Havering
LONDON BOROUGH

London Borough of Havering (20025659) – Suggested Noise Mitigation for Grove Farm

**Figure 3.2 – Grove Farm's suggested location for extra noise attenuation fencing**

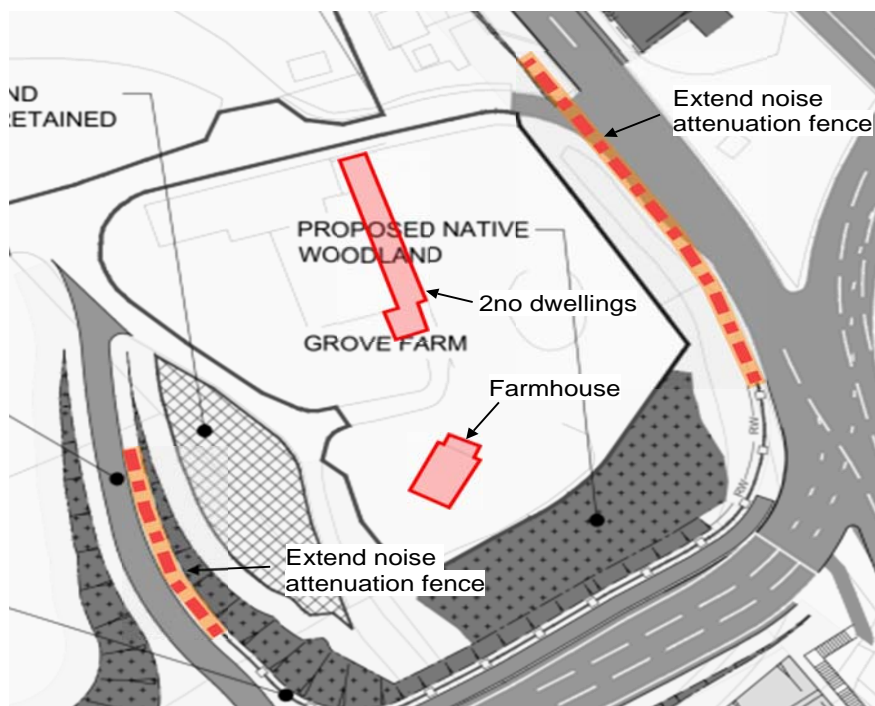
It is noted in representation REP5-067 that the owners of Grove Farm remain concerned that no permanent noise mitigation measures are included in the scheme near Grove Farm. LB Havering shares these concerns.

LB Havering recommends a permanent acoustic barrier 2m above the final carriageway height along the A12 eastbound off-slip road around to the Grove Farm entrance. The barrier can be painted green and planted on the Grove Farm side to soften the view and provide additional vegetative cover.

The benefits of the barrier will be to provide physical separation between motor vehicles and Grove Farm, provide visual interruption between source and receiver, which can reduce psychological awareness of a source, reduce maximum noise levels from short
